Ribble Valley Borough Council  
Housing & Development Control

Application no: **3/2023/0327**

Address: **19 Abbey Road Whalley BB7 9RP**

Proposal: **Outline application for the erection of a detached dwelling with access applied for (all other matters reserved).**

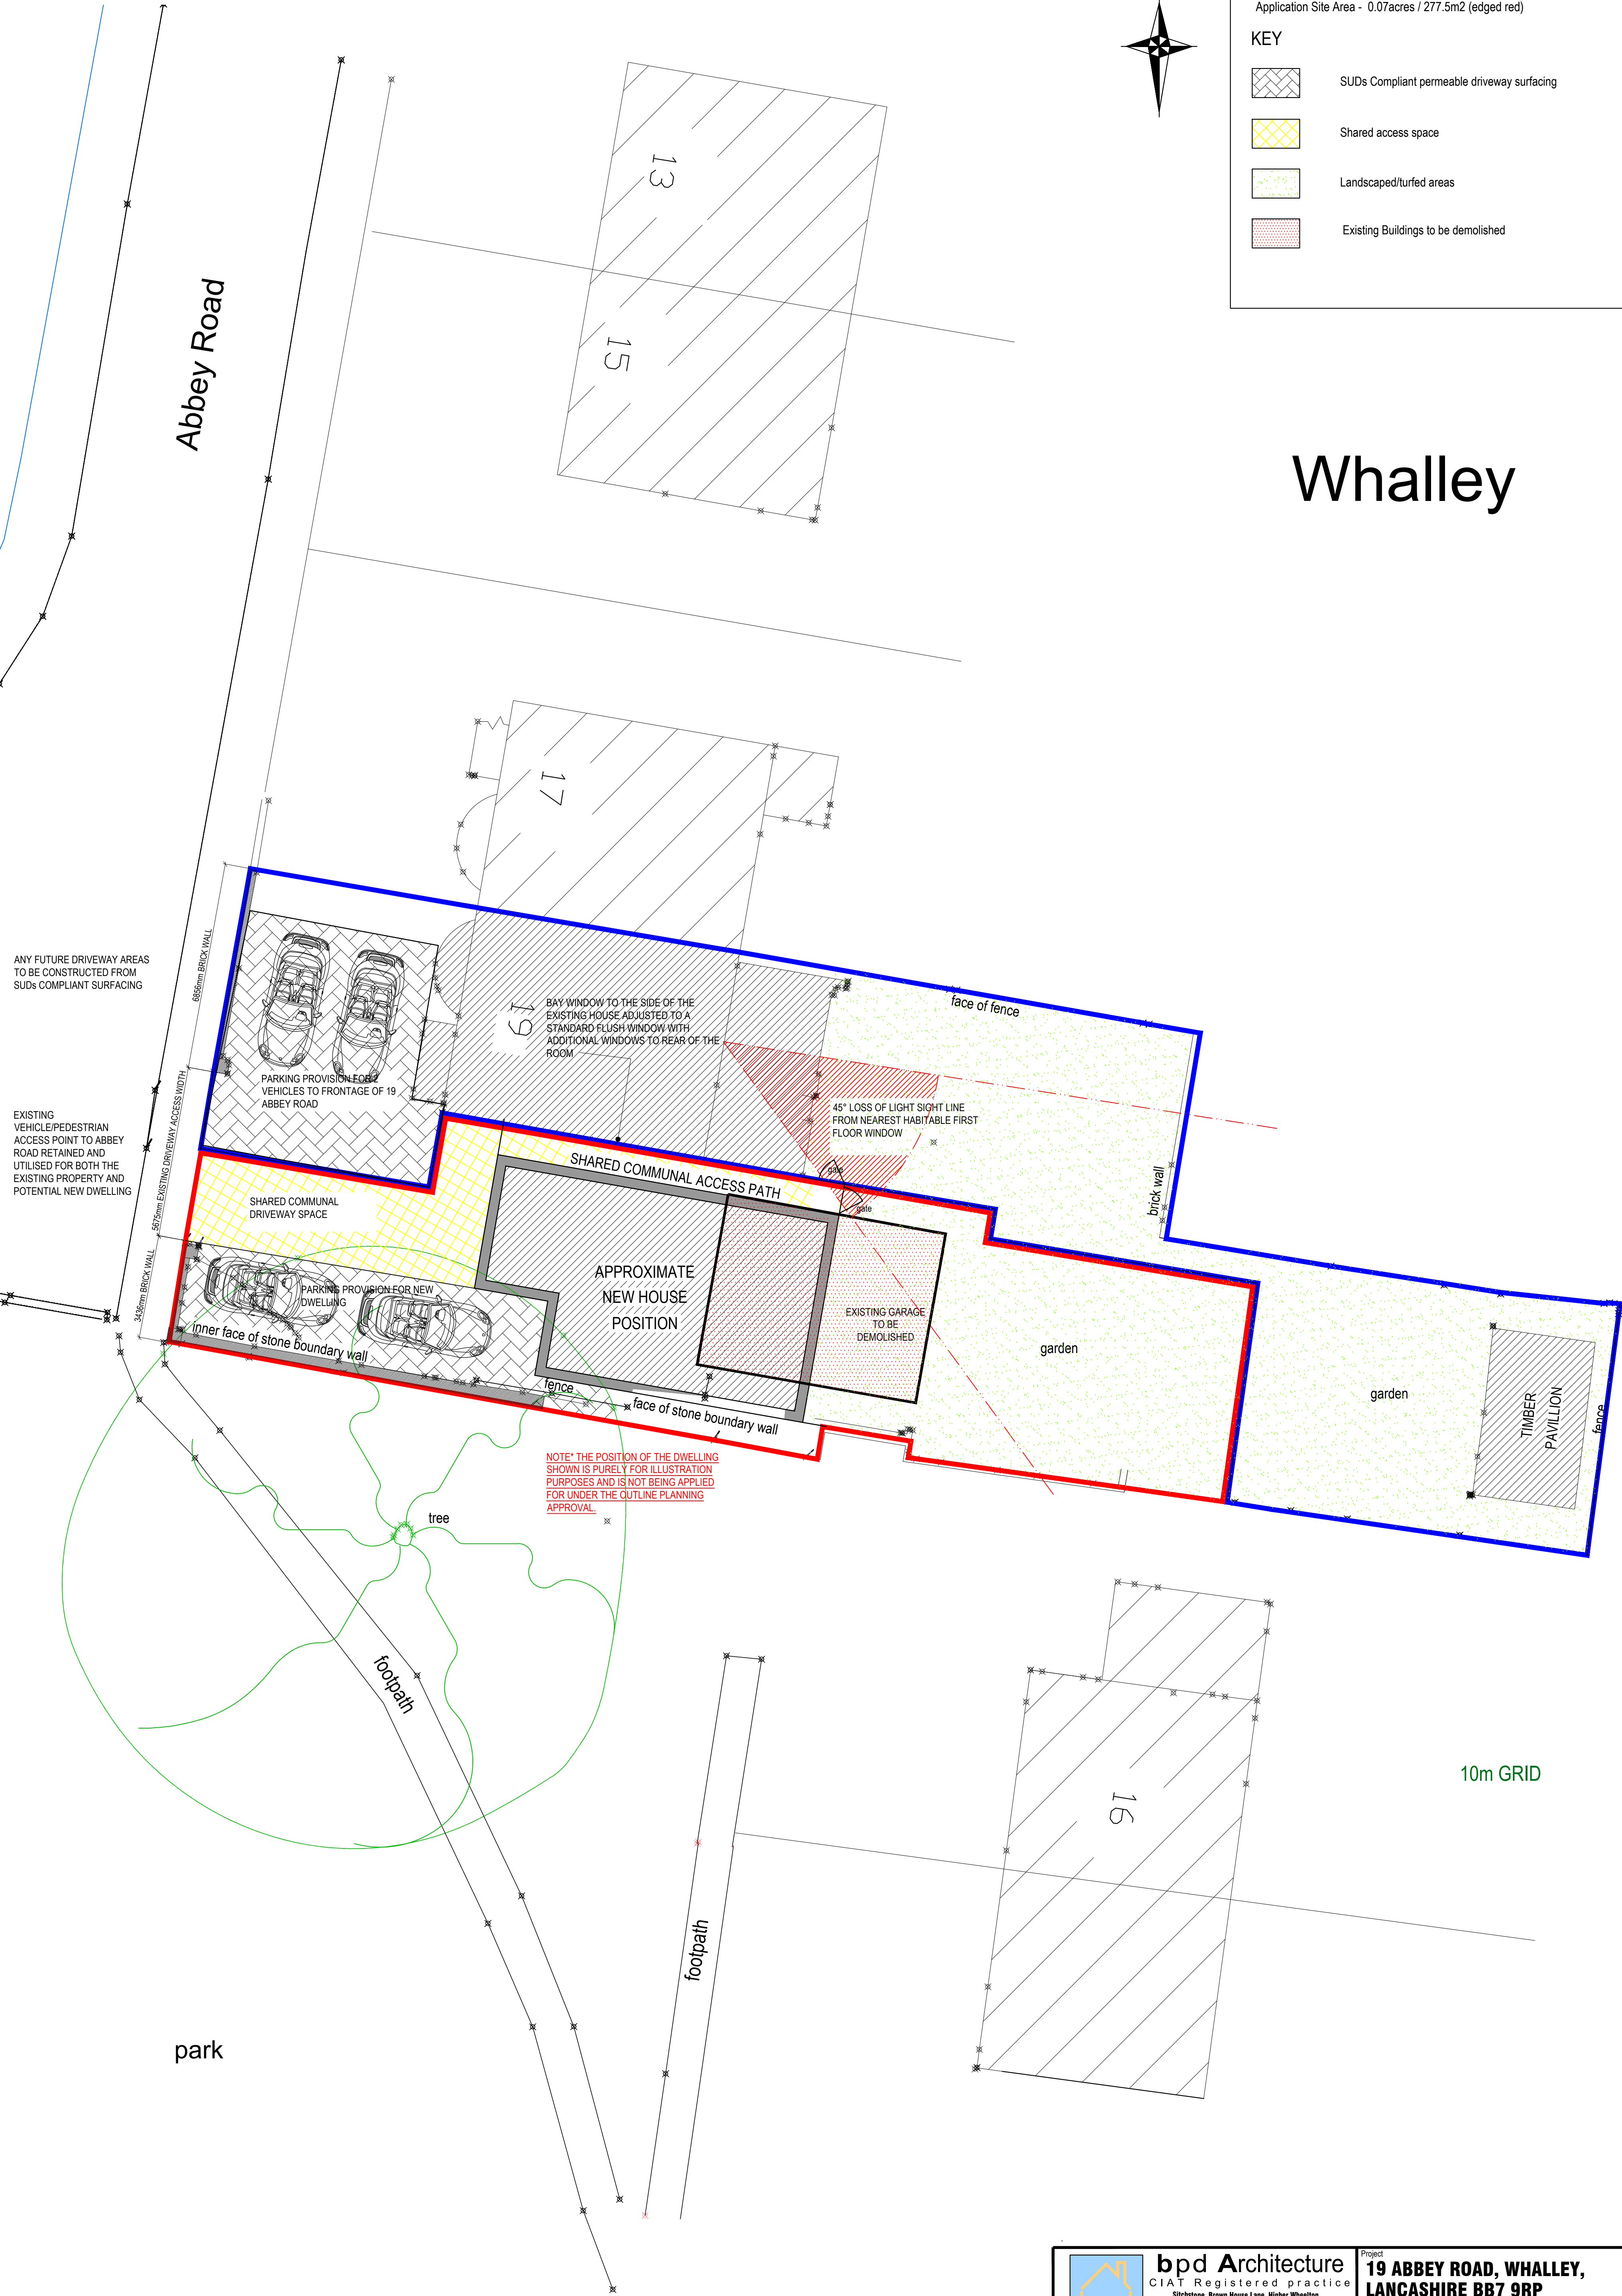
The LHA have reviewed BPD drawing number 1131/ARW/SLP titled "Proposed Site Layout Outline Application for Dwelling" and are aware that the proposed dwelling will use the existing access which serves the single dwelling.

The LHA are aware that the access is 5.675m wide, which does comply with the LHAs access guidance when serving two dwellings, but the LHA will request that each dwelling has its own independent access to prevent any obstructions and potential conflicts associated with the communal area and access. These concerns are associated with the proposed parking area for the proposed dwelling. Even though this will be addressed during the reserved matters stage, BPD drawing number 1131/ARW/SLP shows that the parking area for the proposed dwelling will be provided in tandem.

However, the provided parking area for the proposed dwelling will not be located adjacent to the proposed access. Instead, the vehicles exiting the site will need to undertake complex manoeuvres internally to exit the area, which could lead to the vehicles overlapping number 19s driveway. Therefore, for ease and to prevent any potential social conflicts between the occupants of the two dwellings, the LHA will request that each dwelling has its own independent access which should be a minimum of 4.8m to ensure that two car parking spaces can be provided on each driveway.

As a result, the LHA require this to be shown on an amended drawing.

The LHA require an amended drawing showing that the site will provide each dwelling with its own independent access, which should be a minimum of 4.8m wide to ensure that 2 car parking spaces can be provided on each driveway.
